Consultation Response from Jamie Turner KC, Highways Development Management		
2021/91975 Croft House Surgery, 1145, Manchester Road, Slaithwaite, Huddersfield, HD7 5JY		
Redevelopment of Croft House Surgery with demolition of existing 2 storey flat roof car port / office building, alterations to existing building to form 4 residential units and erection of 2 dwellings (within a Conservation Area)		
Date Responded: 26/10/21	Responding Officer: J Turner	Responding Ref: K1-42/25

This application seeks approval for the redevelopment of Croft House Surgery with demolition of existing 2 storey flat roof car port / office building, alterations to existing building to form 4 residential units and erection of 2 dwellings (within a Conservation Area) at Manchester Road, Slaithwaite.

Proposed Site Plan 1:100

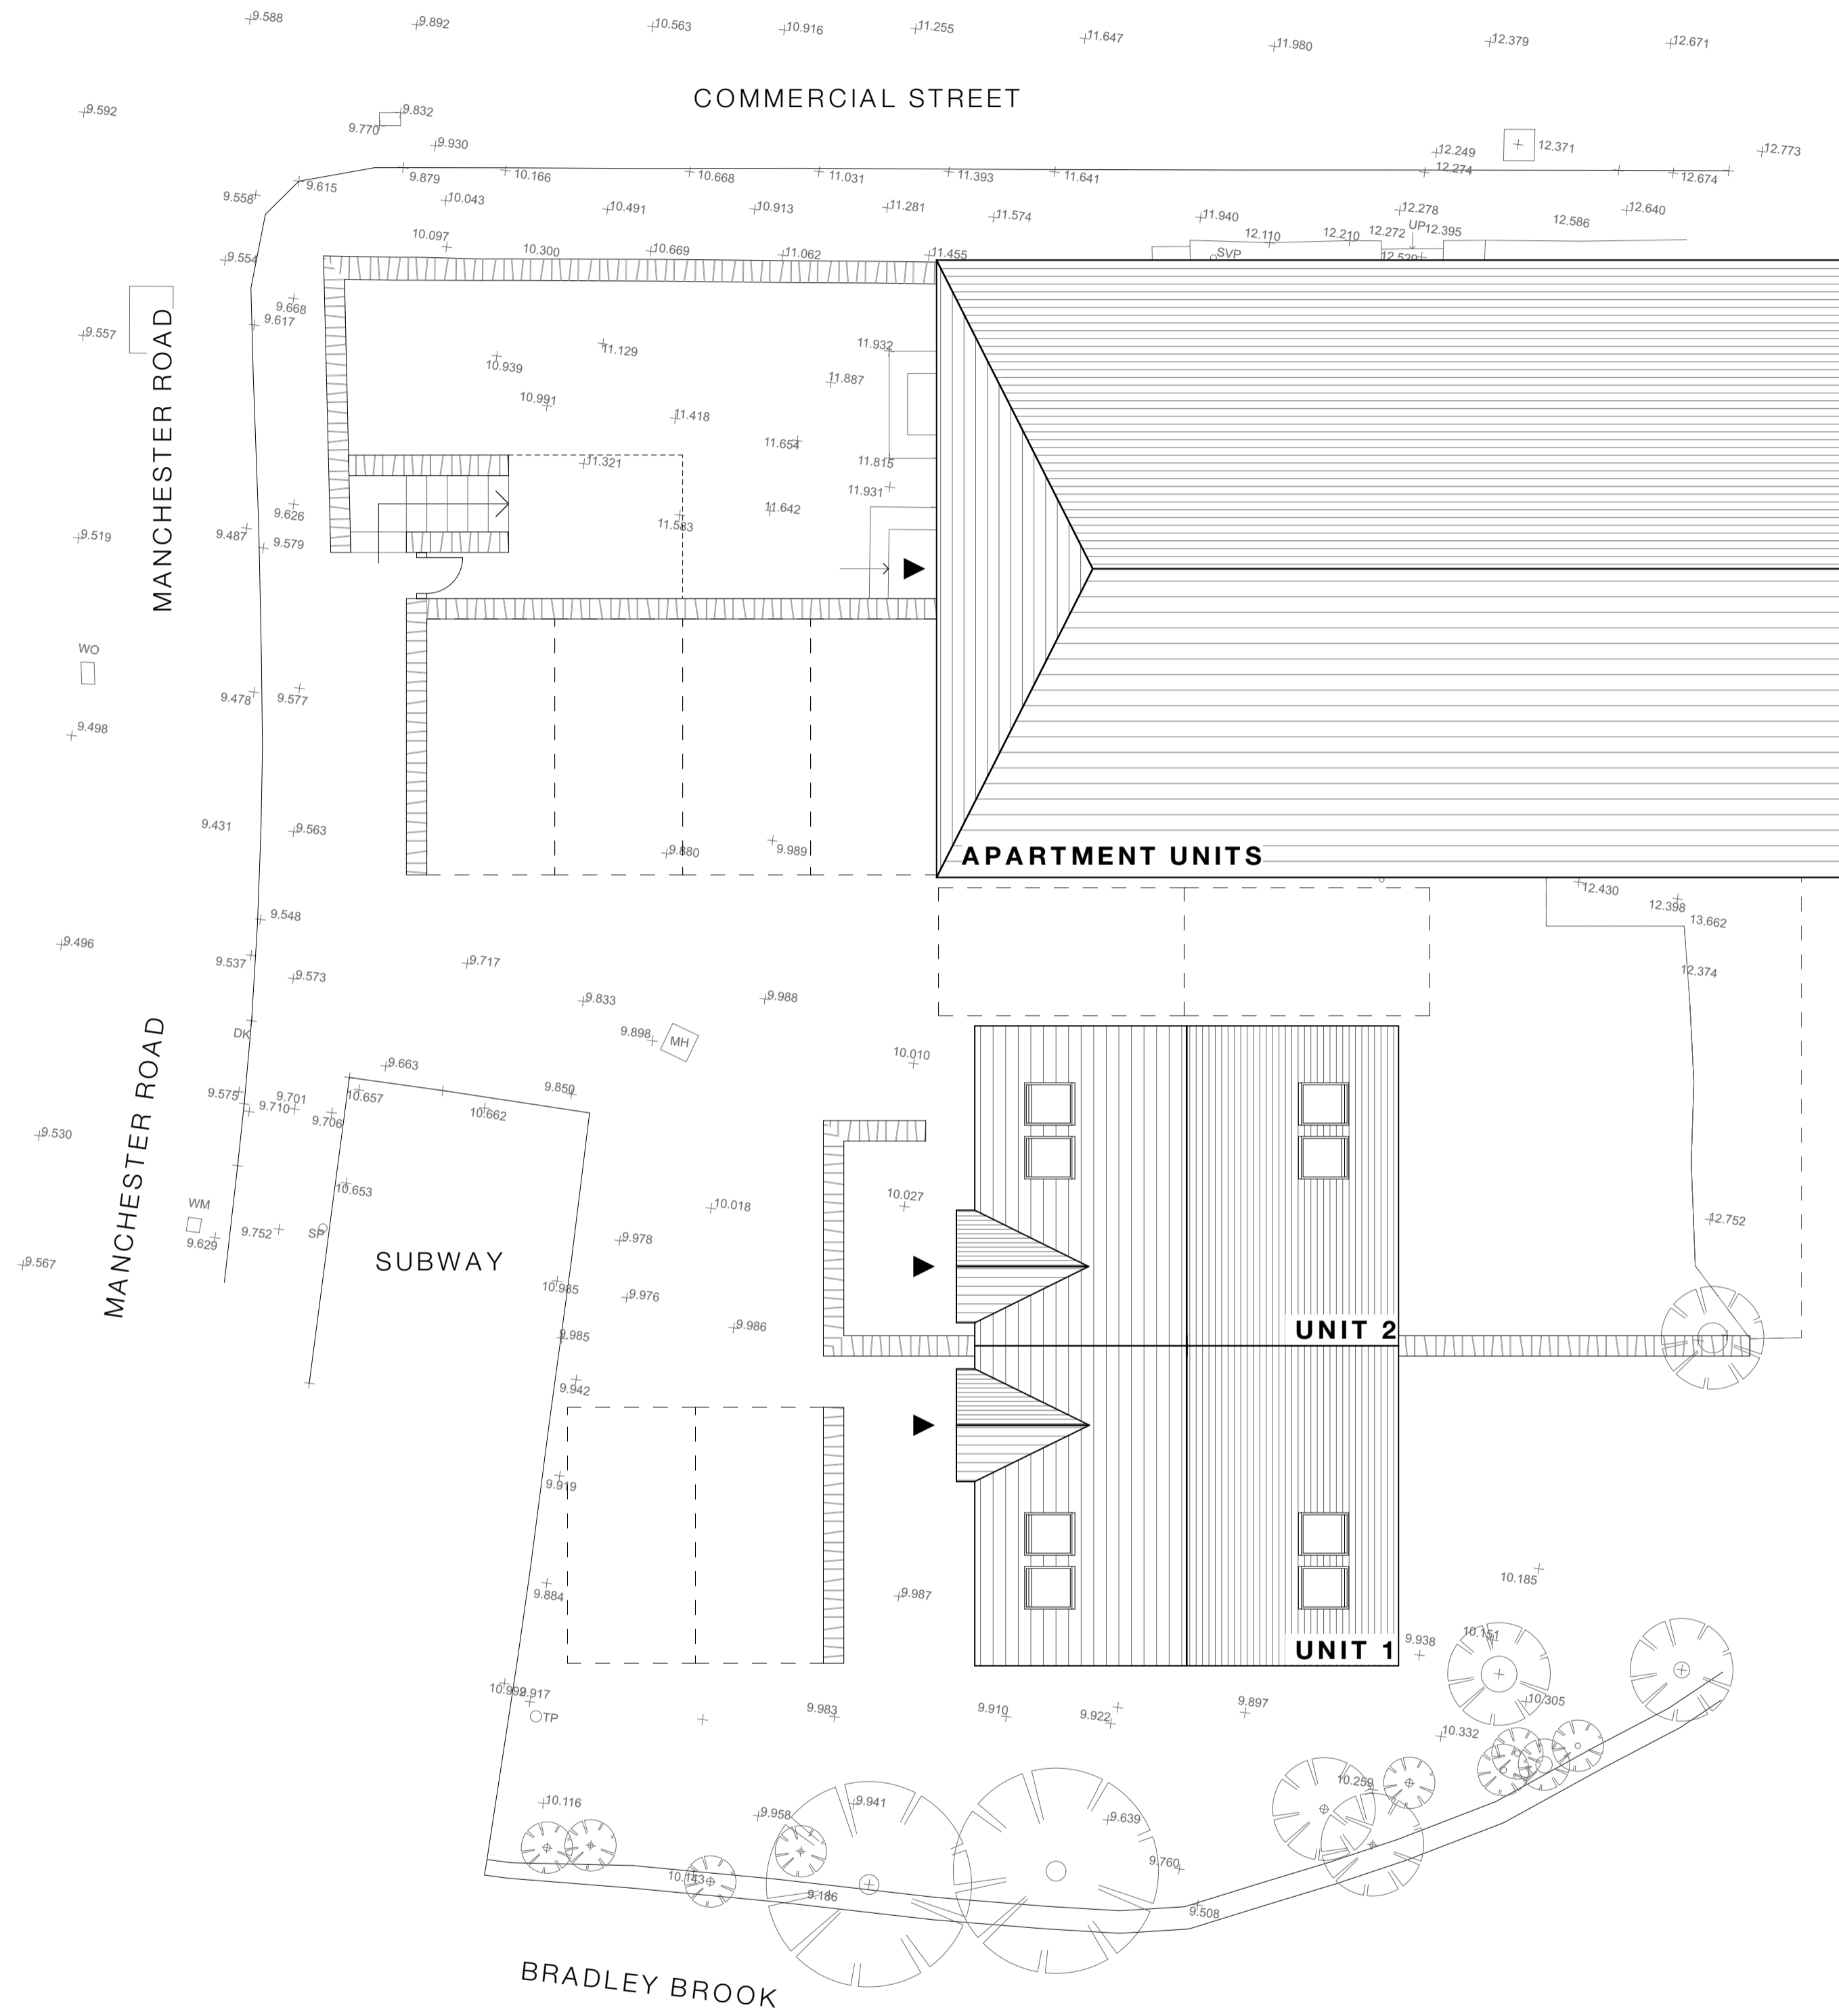
Further to previous comments, the proposed number of properties has been reduced, and the available off-street parking is now more in-keeping with the proposed dwellings. However, the parking spaces anticipated to be used for apartments 3 and 4 appear difficult to manoeuvre into and out of. Highways DM would expect a minimum clearance of 6.0m from a parking space whereas the shallowest point measures approximately 4.2m. It seems unlikely this can be rectified given the location of the subway entrance, so swept path analysis should be provided to demonstrate that these spaces work, especially the one proposed for Apartment 4.

Bin and cycle storage appears to be underground. Even if these were private bins for each apartment, it isn't acceptable to expect resident to pull their full bins up a flight of stairs to be presented for collection. Given the apartments may share one large communal bin, this is even less of a practical arrangement. This should be rectified, and the proposed bin storage and collection spaces dimensioned on a plan. Additional detail on the proposed cycle store (dimensions, cycle stand design and installation etc.) should also be submitted.
